Senders ref: SSD-8903-MOD3

**Subject: EES comments on Modification Application for Stage 1 of Ivanhoe Estate,
Macquarie Park - SSD-8903-MOD 3**

Subject: EES comments on Modification Application for Stage 1 of Ivanhoe Estate, Macquarie Park - SSD-8903-MOD 3

**ADDITIONAL TREES  
TO BE REMOVED**

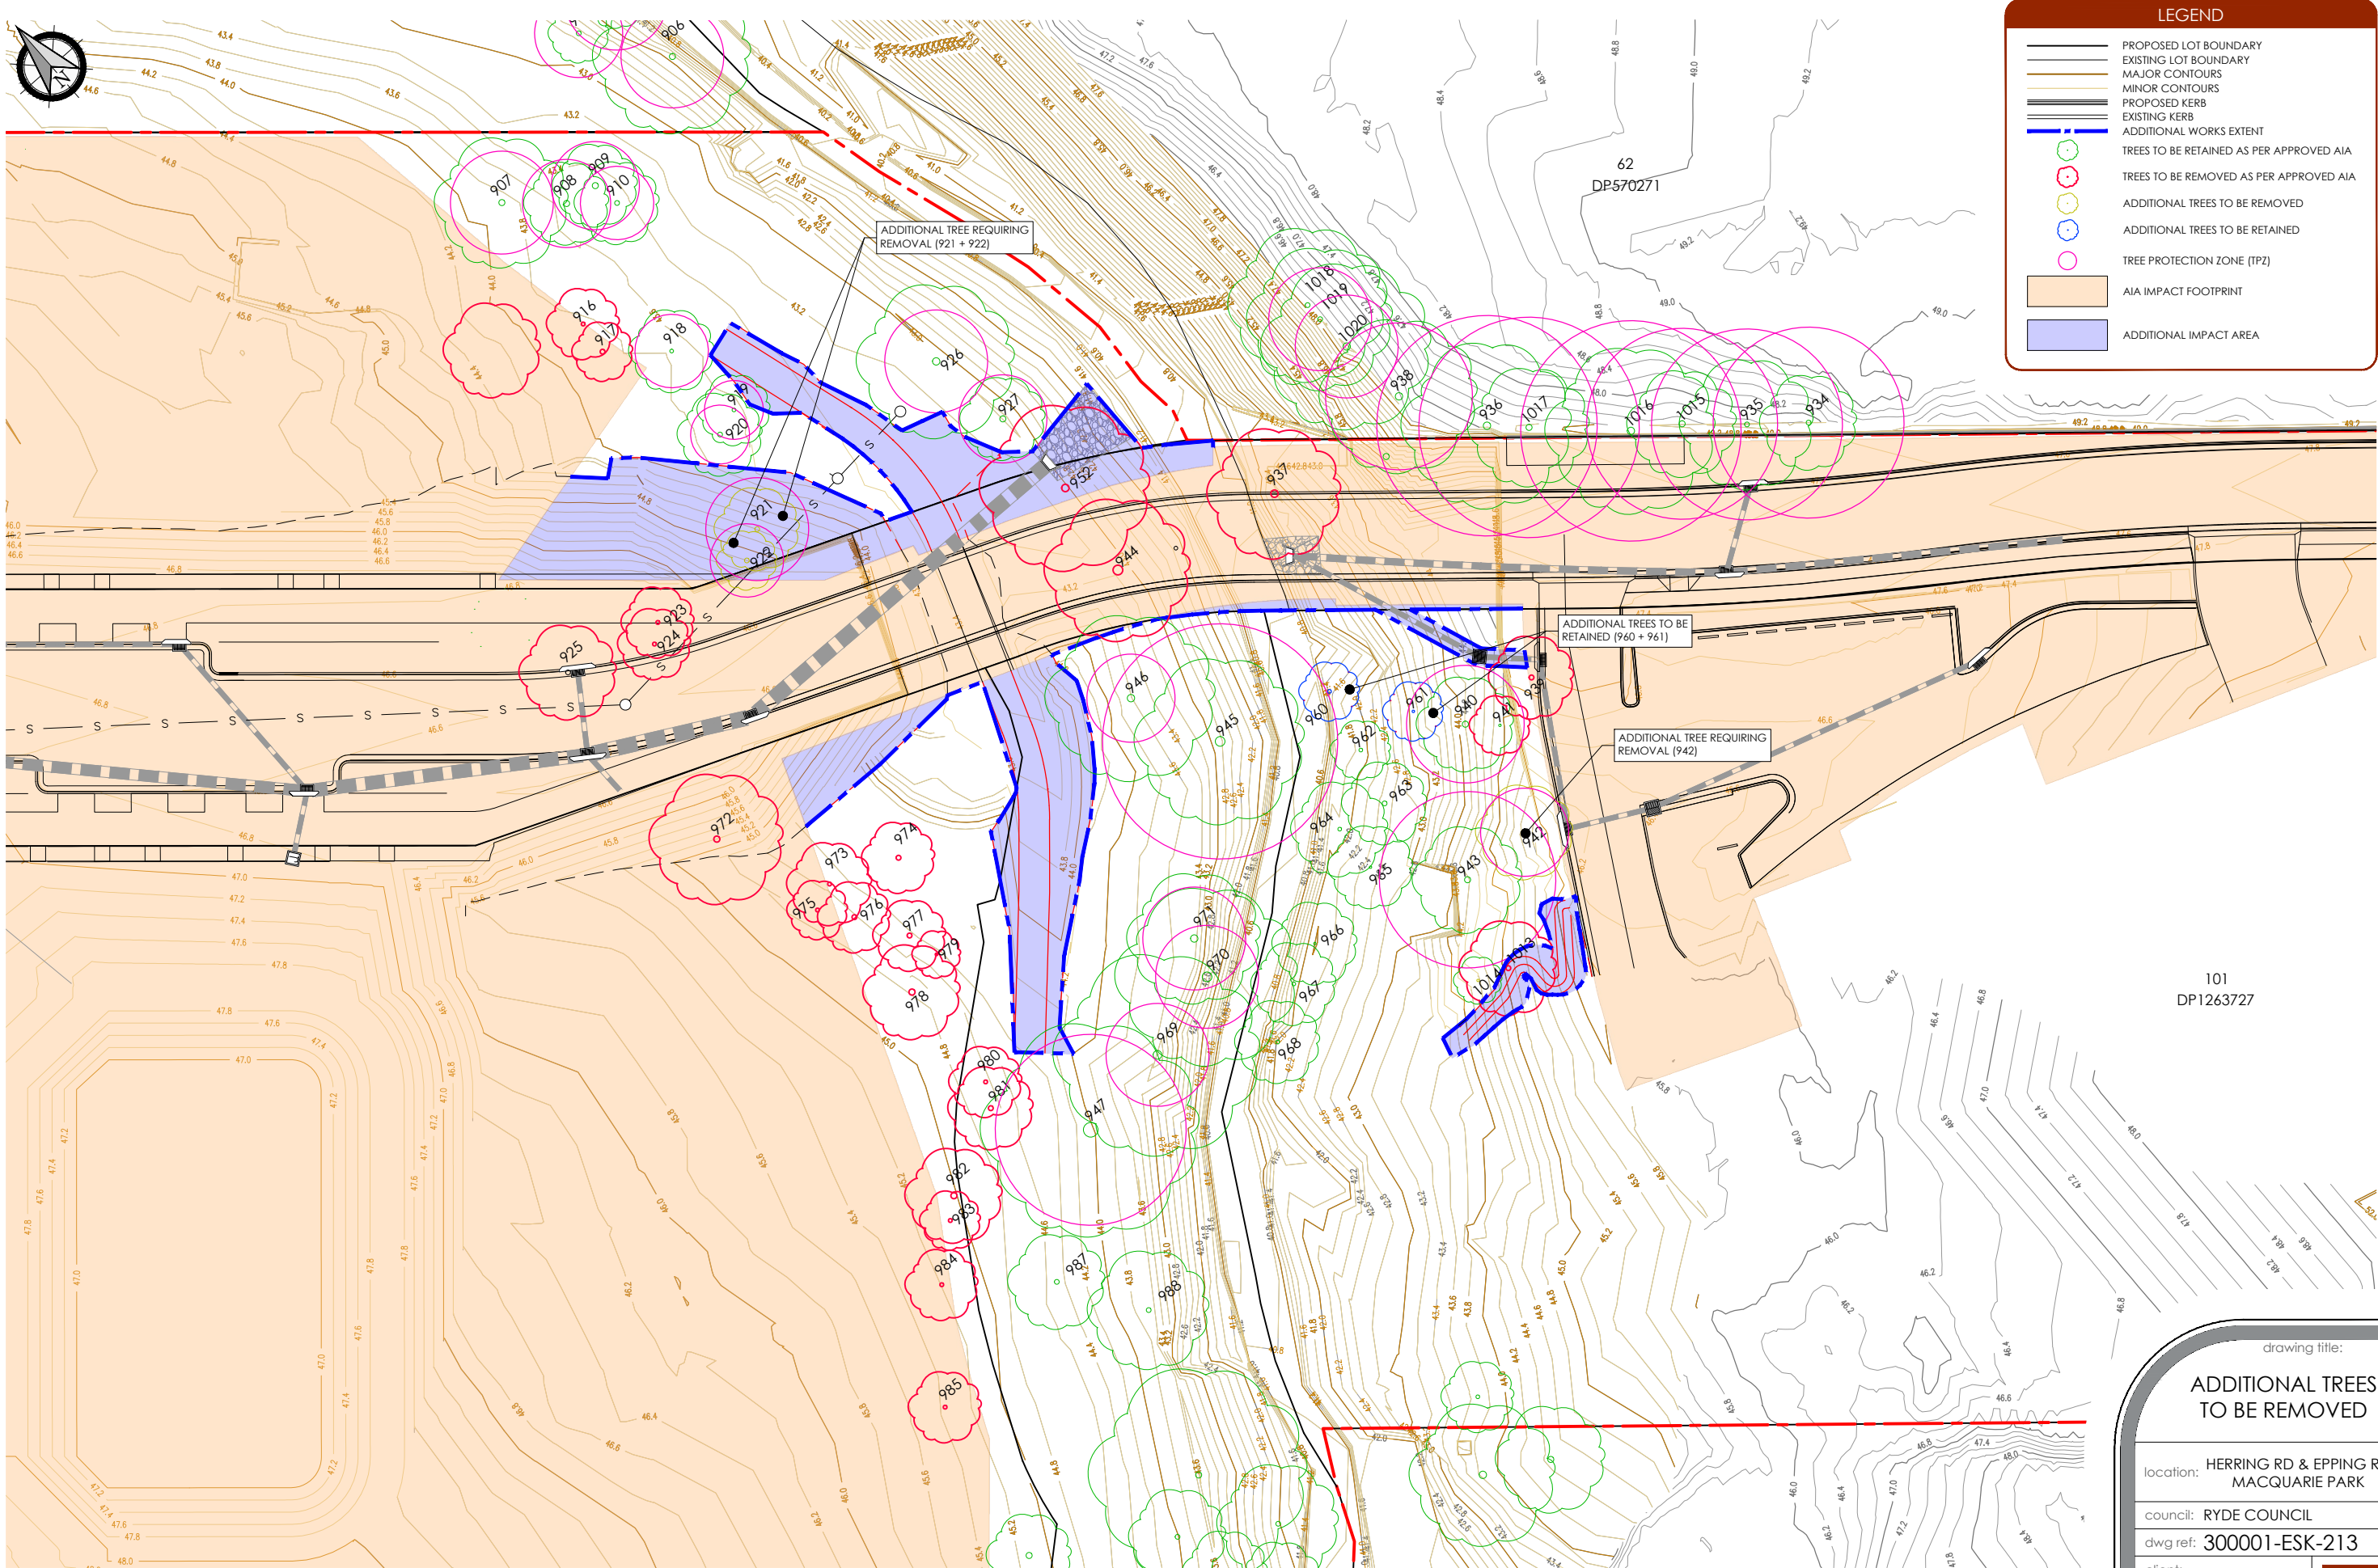
The modification seeks to remove three trees (921, 922 and 942) that were approved for retention, and retain two trees (960 and 961) that were approved for removal but they are no longer required to be removed resulting in a net loss of one (1) tree as part of the site preparation works being undertaken as Stage 1 of the Ivanhoe Estate redevelopment.

The Impact Assessment notes two of the trees (921 and 922) proposed for removal are *Angophora costata* and the other tree (942) to be removed is *Corymbia maculata*. Table 3 of the AIA indicates the two *Angophora* trees (921 and 922) have a high retention value. This means “these trees are considered important and should be retained and protected where design allows” (see Section 2.2 of the AIA). EES notes the *Corymbia maculata* tree has been assigned low retention value (Table 3, AIA). The RtS needs to provide details on why the *Angophora* trees are considered to have a high retention value and whether any of the trees to be removed contain nests, dreys, hollows etc.

The Impact Assessment provides no details on the two trees that are now proposed to be retained (trees 960 and 961) and neither does Table 3 in the AIA which lists the tree species as ‘unidentified’. Nor does the AIA provide details on the tree height, Diameter at Breast Height (DBH), retention value etc of these two trees. It is unclear if the two trees which are now proposed to be retained are local native species or exotic or if they have a high or low retention value. The Impact Assessment notes in retaining these two trees there is a net change of -1 trees however, details are required on the habitat value of these trees compared to the three native trees which are proposed to be removed. The RtS needs to provide details on this.

As the three trees were initially approved to be retained, and there is no information available in the AIA on the two trees that are now proposed to be retained, EES recommends the trees proposed to be removed are replaced at a ratio greater than 1:1 (for trees not covered by a biodiversity offset strategy) to mitigate the urban heat island effect and to enhance tree canopy and habitat on the site. The loss of existing trees and the benefits that they provide can take years for a juvenile tree to grow and replace.
